Project Name : Land West of B2132 Bilsham Road, Yapton
Job No : 14-111
Note Title : Flood Risk Assessment & Drainage Strategy – Addendum No.2
Author : NA
Checked : GG
Approved : GG
Date : June 2018

1.0 INTRODUCTION AND BACKGROUND

1.1 Odyssey was commissioned by Gleeson Strategic Land to undertake a Flood Risk Assessment (FRA) and Drainage Strategy in support of a planning application for a proposed residential development in Yapton (report no. 14-111-17B).

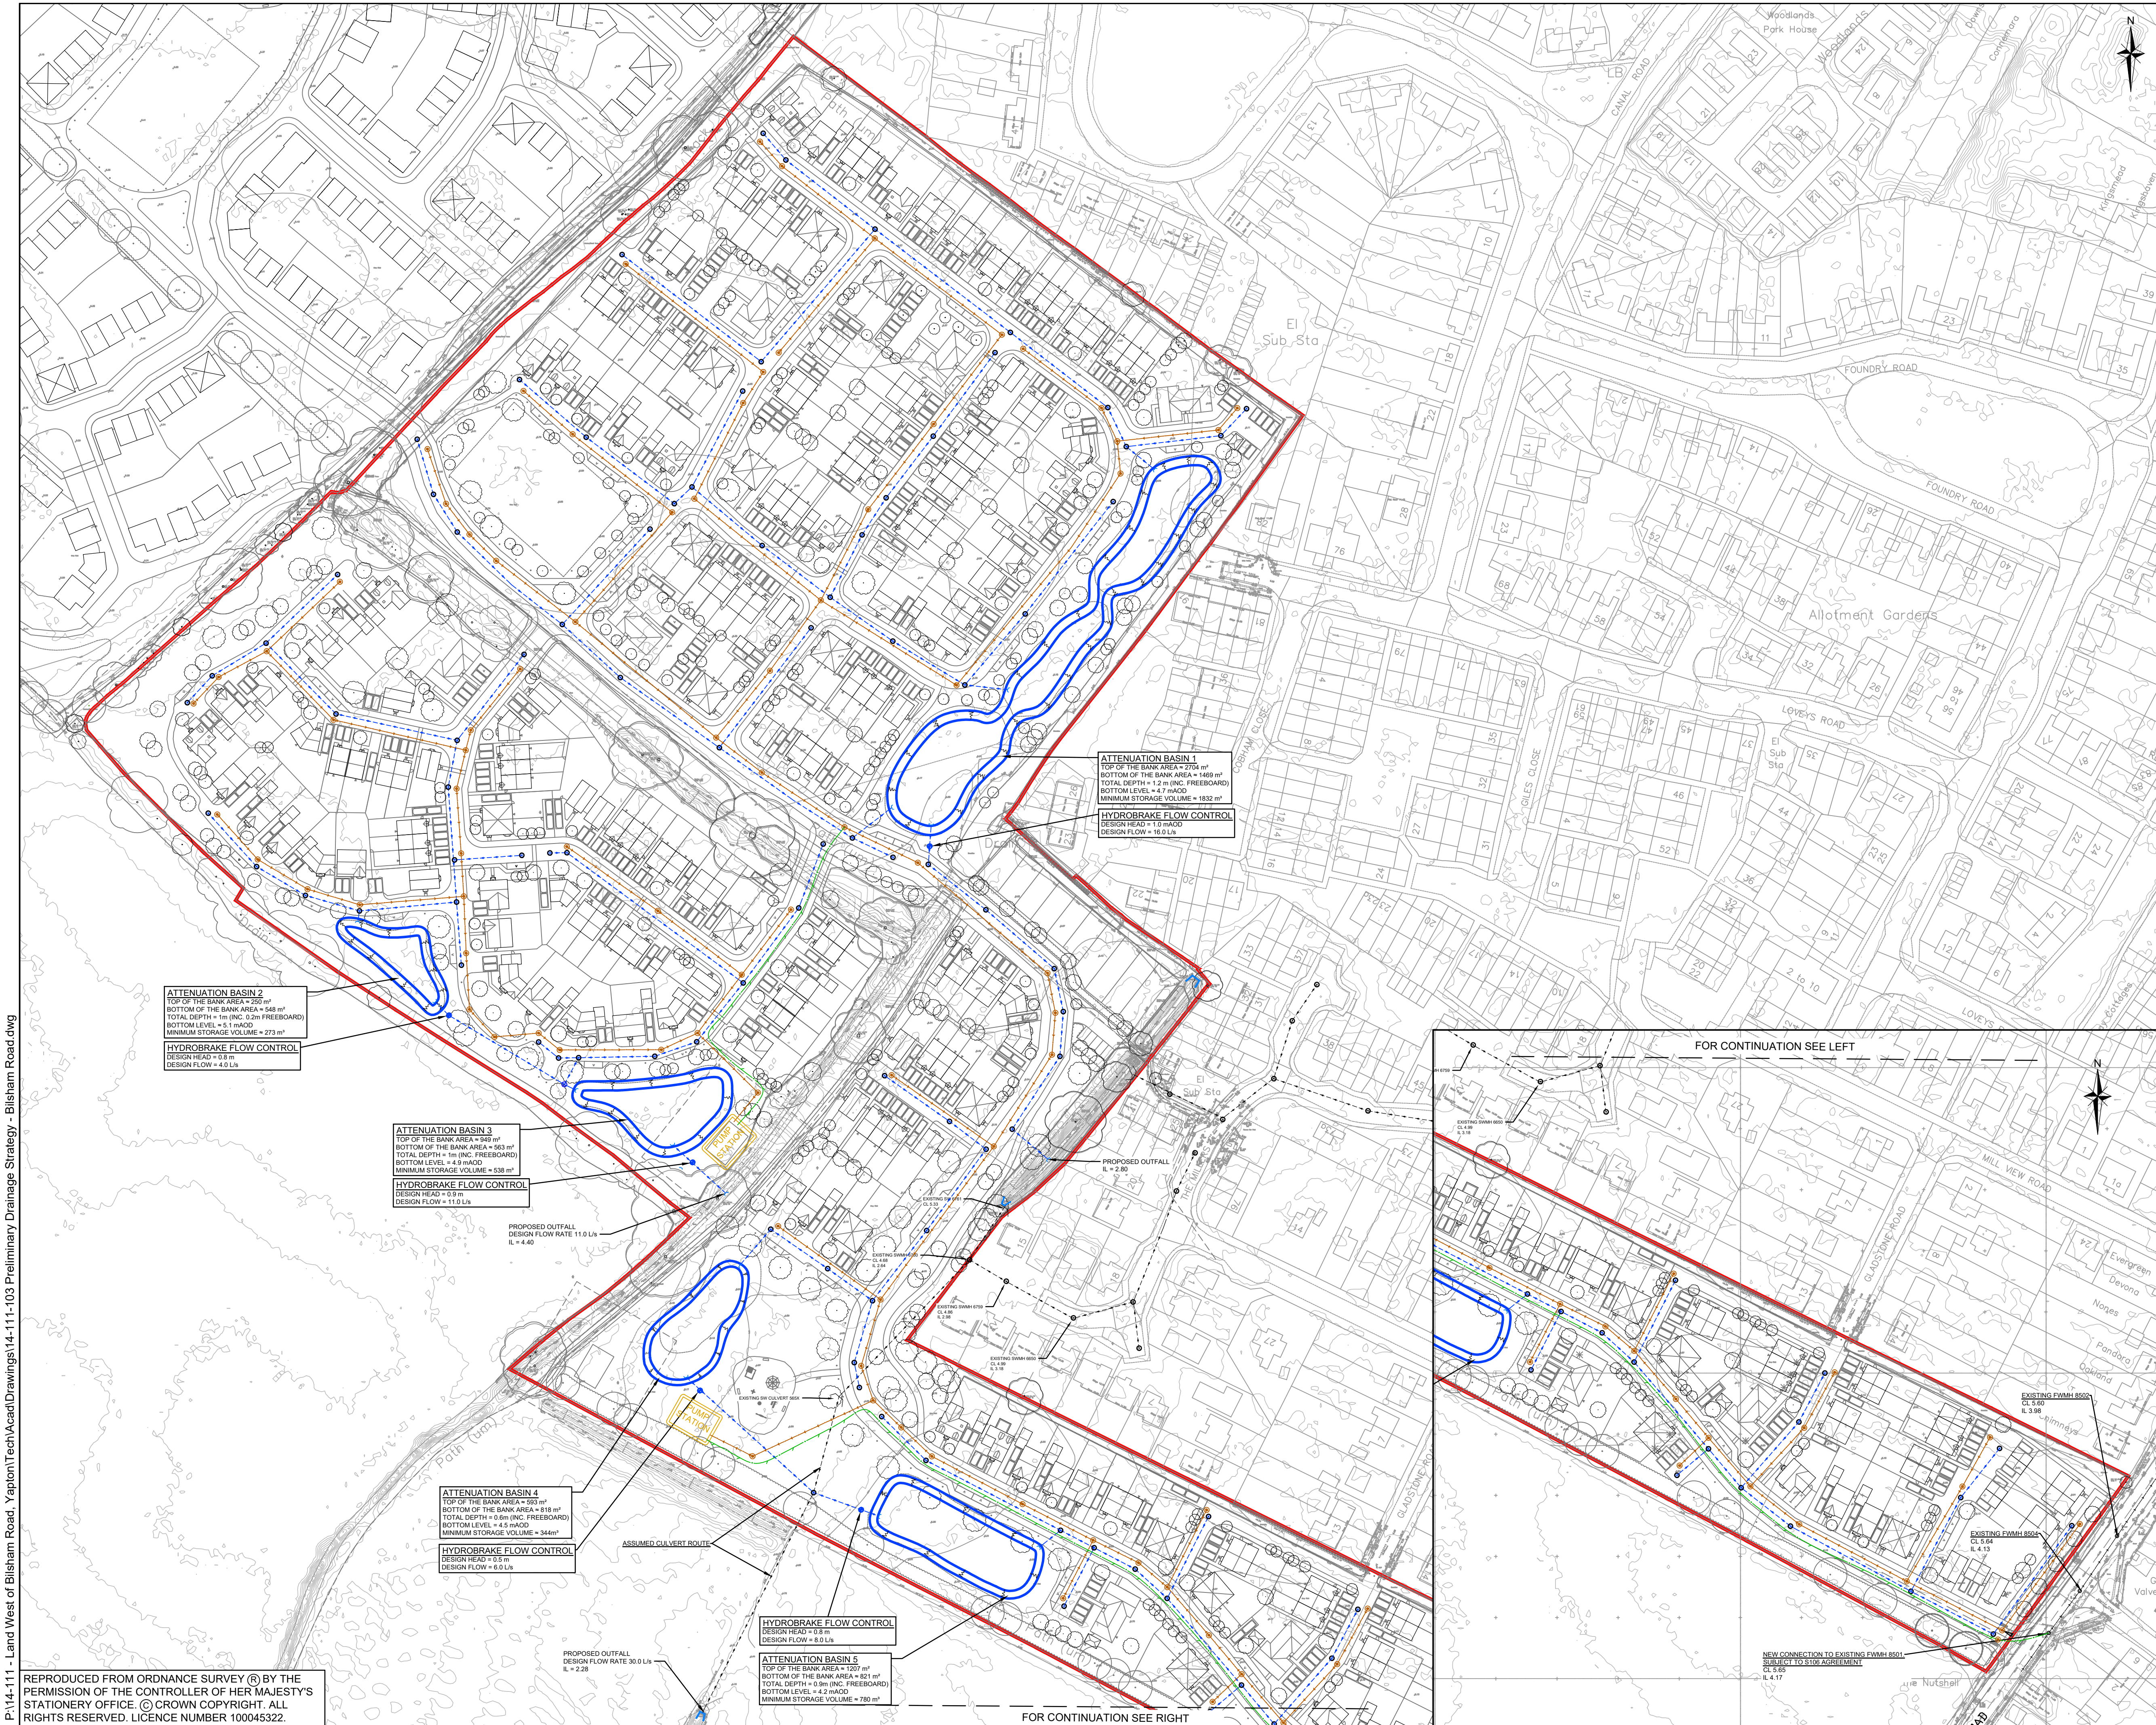
- *We note that groundwater monitoring was conducted in late October. For a development of this size, we require monitoring to be completed from October through to March, i.e. the current monitoring results are insufficient.*
- *Discharge rates of $\times 10^{-6}$ are not poor enough to justify ruling out infiltration in the surface water drainage strategy. Infiltration is achievable at such a rate. Therefore, the overall strategy would need to be revised.*

- A plan showing the locations of percolation test pits would also be required.
- We do not require 1m clearance between the base of any proposed infiltration structure and maximum recorded groundwater levels. Therefore, a maximum recorded groundwater level of 1.69m bgl is not too high to rule out the use of infiltration. Shallow infiltration structures can be used with maximum groundwater levels of 1m bgl.

3.1 The submitted drainage strategy was based on the October groundwater monitoring results, and it has since been revised in accordance with the results of the additional groundwater monitoring.

3.2 The ADC Drainage Engineer notes that infiltration is achievable at the rates encountered at the site, and that shallow infiltration structures can be used with maximum groundwater levels of 1m bgl. However, groundwater levels were found to be higher between January and March than in October, and the maximum recorded groundwater levels were higher than 1m bgl within the trial pits located in close proximity to the proposed basins. As such, infiltration will not be practicable at the site and surface water runoff will be discharged to the watercourses on site.

3.3 The groundwater levels at Attenuation Basin 1 (borehole WS02) were found to be particularly shallow between January and March. In order to mitigate the impact of groundwater in this location, the depth of Attenuation Basin 1 has been reduced and will be lined. To account for the loss of attenuation volume within the basin, it is proposed to implement a lined cellular storage tank within the public open space to the west of the development parcel. The tank will discharge flows to Basin 1 at a restricted rate.

3.4 Attenuations Basins 2 and 3 have also been reduced in depth and will be lined to mitigate any impacts of shallow groundwater. All basins will have infill material on top of the proposed liner to counter any buoyancy effects.

3.5 The basins and cellular storage tank shown on the proposed drainage strategy have been sized to attenuate flows for all rainfall events up to the 1 in 100 year event plus 40% to account for climate change, whilst restricting total discharge rates to less than the Q_{BAR} value for the site.

3.6 The proposed surface water drainage strategy is outlined in Drawing 14-111/103A in **Appendix C**, along with the associated Micro Drainage calculations.
